DECISION DELEGATED TO HEAD OF PLANNING

Application No: H14-0889-25 **Applicant:** Mr J Carter
Proposal: Conversion of agricultural barn to residential dwelling
Location: Nunnerley House Farm Leaveslake Drove West Pinchbeck
Terminal Date: 12th December 2025

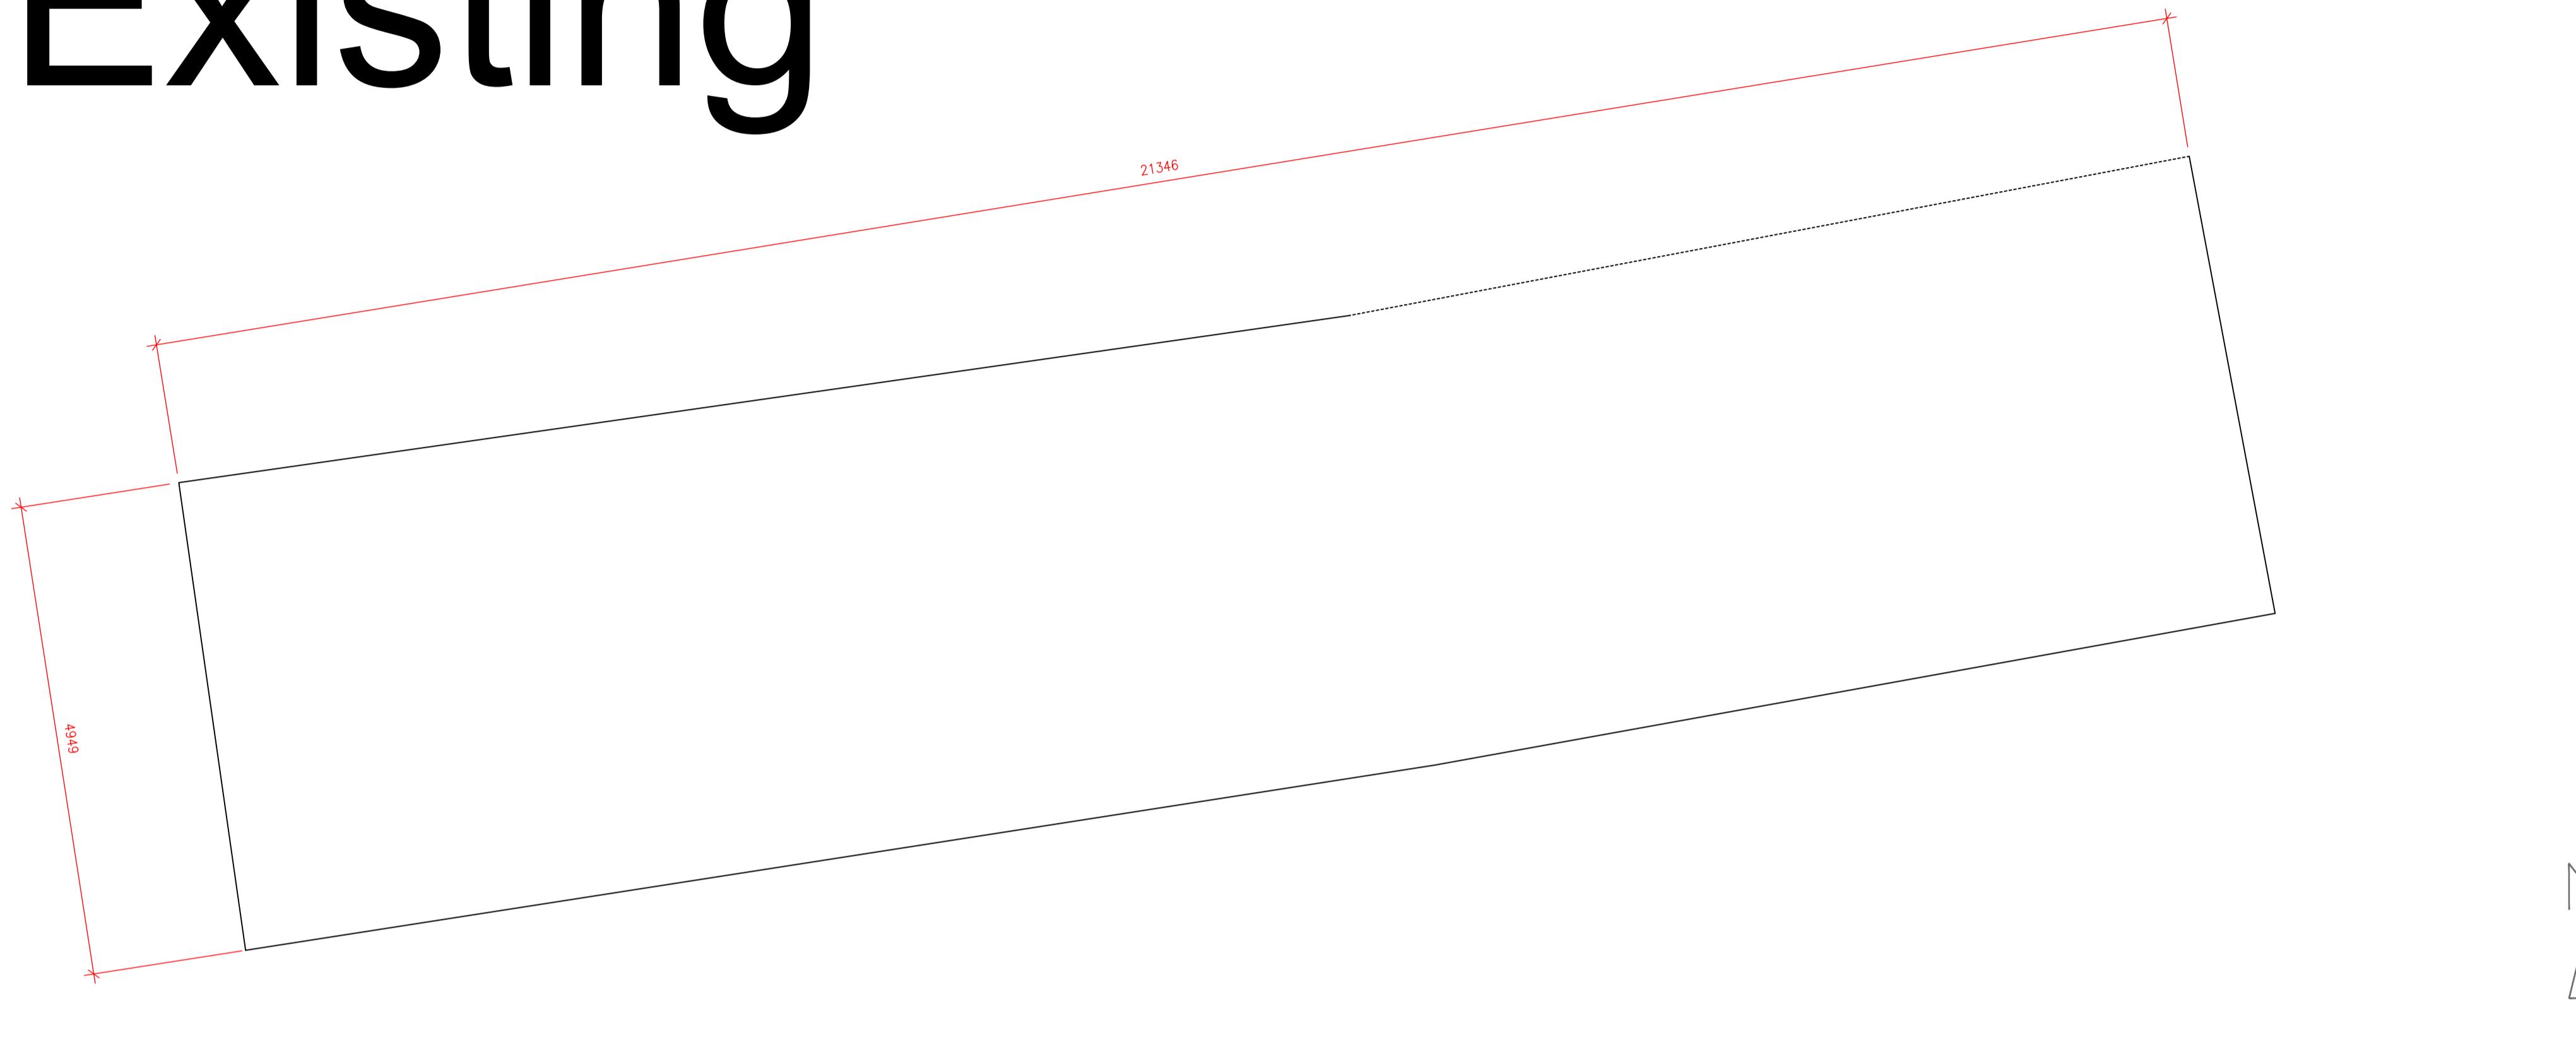
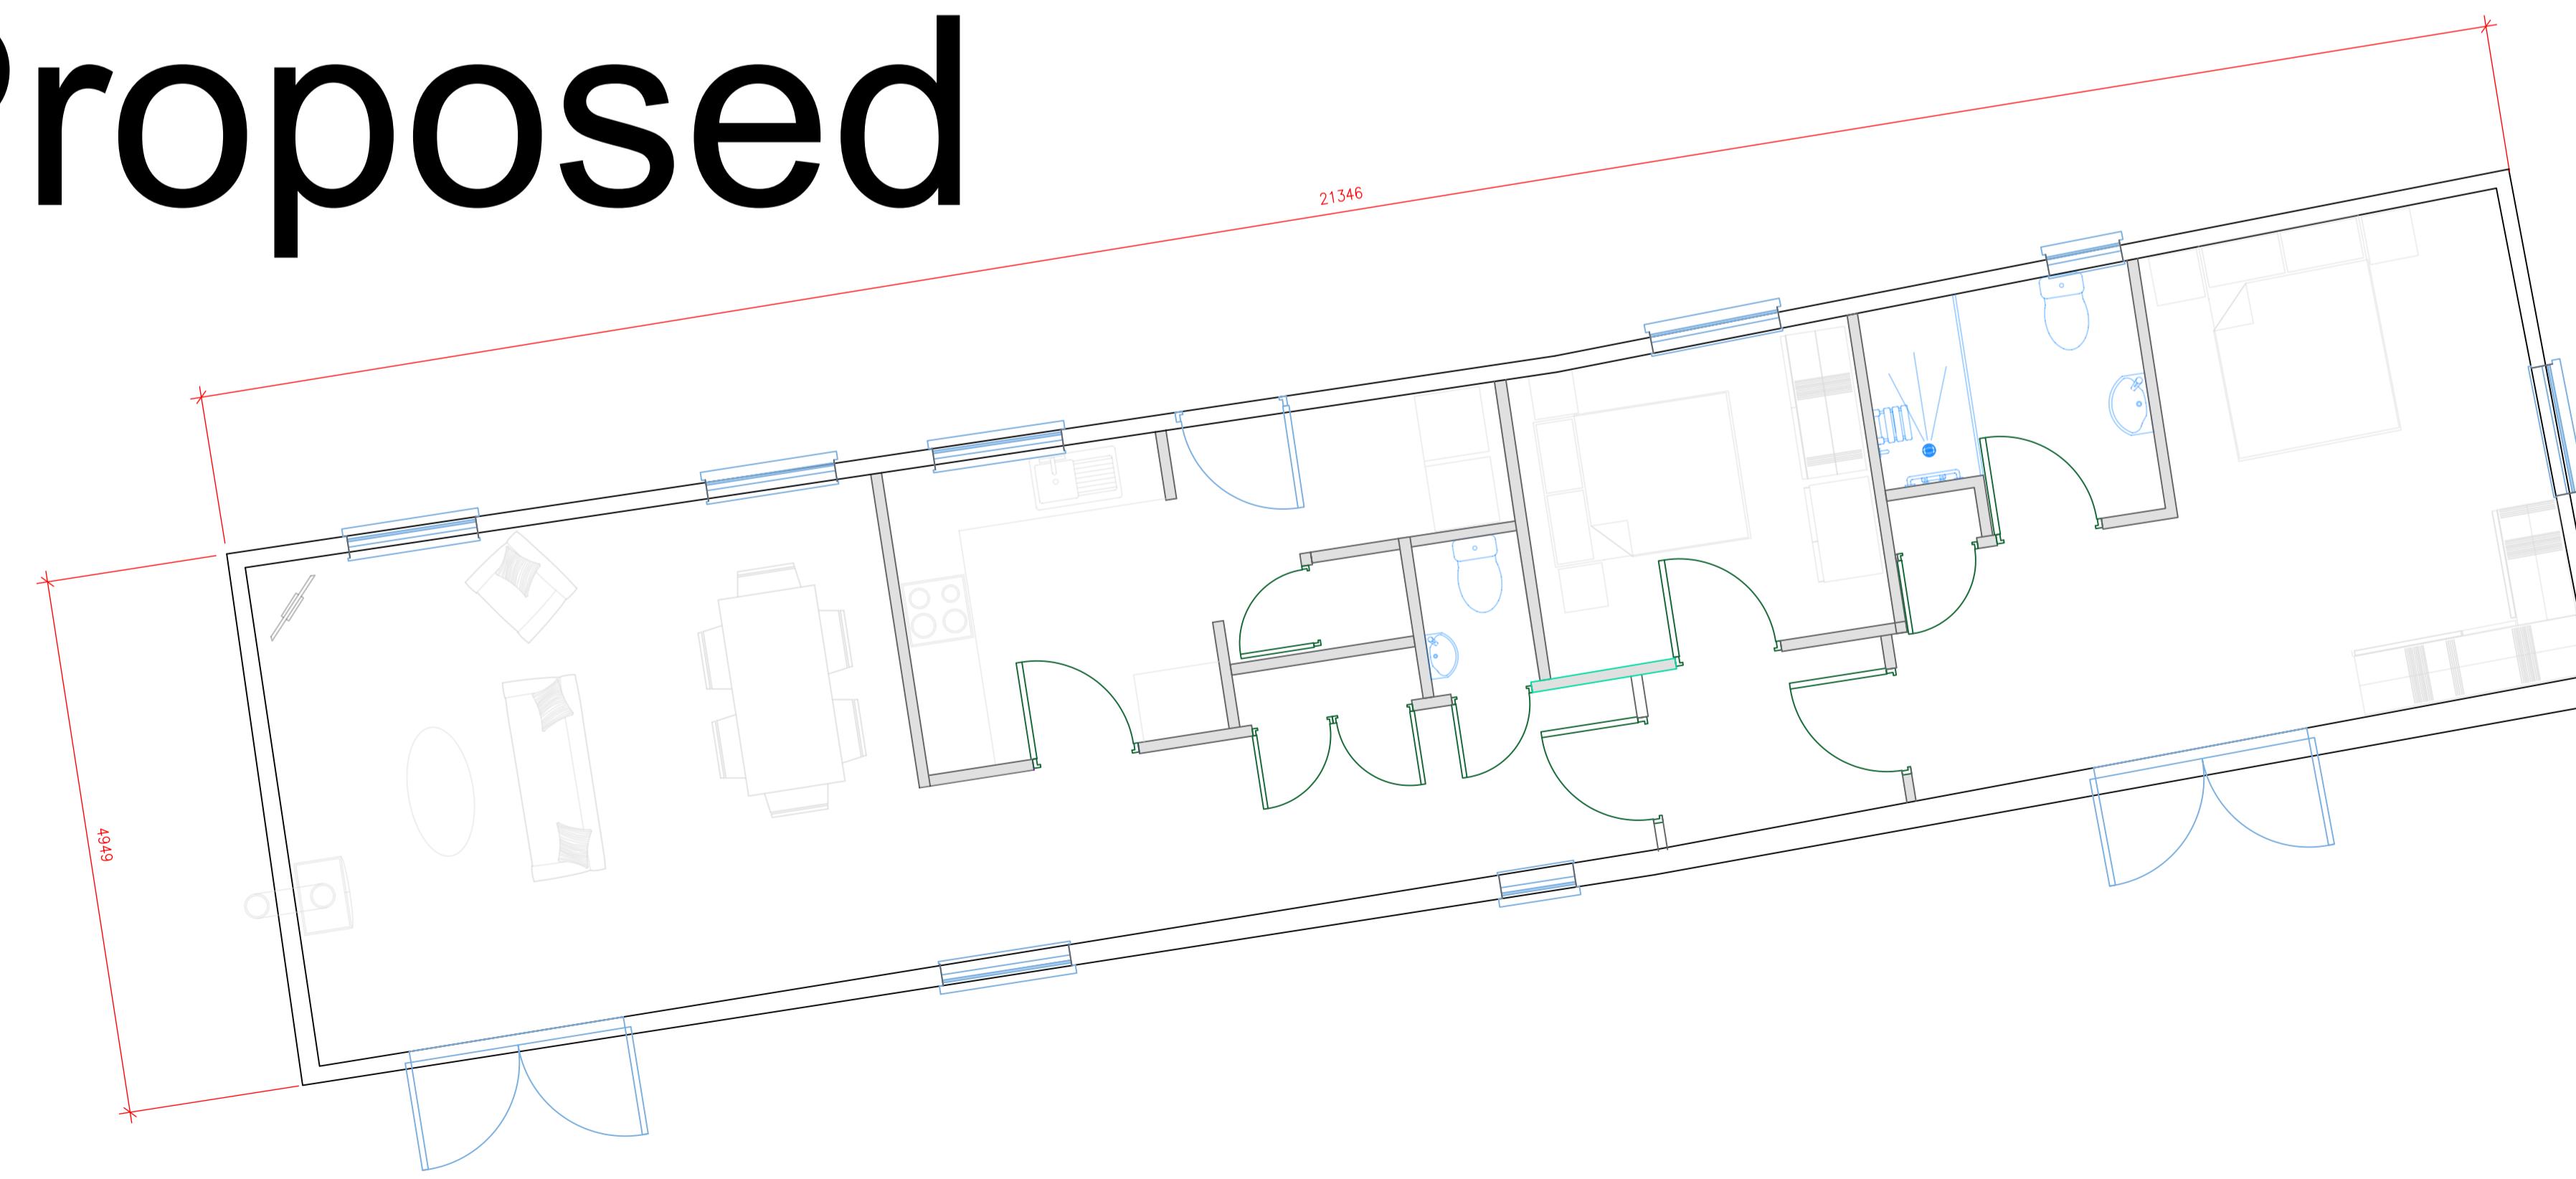
After conducting a site visit, it was apparent that the submitted plans did not accurately show the building within the site that is proposed for conversion. This was queried with the applicant's agent and amended plans were subsequently provided which were considered to be more accurate. A structural survey report was also provided.

- National Planning Practice Guidance and case law make it clear that development under Class Q should not be so extensive as to amount to a 're-build'. As set out previously, initially the submitted plans were inaccurate, and this became evident after undertaking a site visit. Amended plans have been submitted to show the existing and proposed building more accurately.
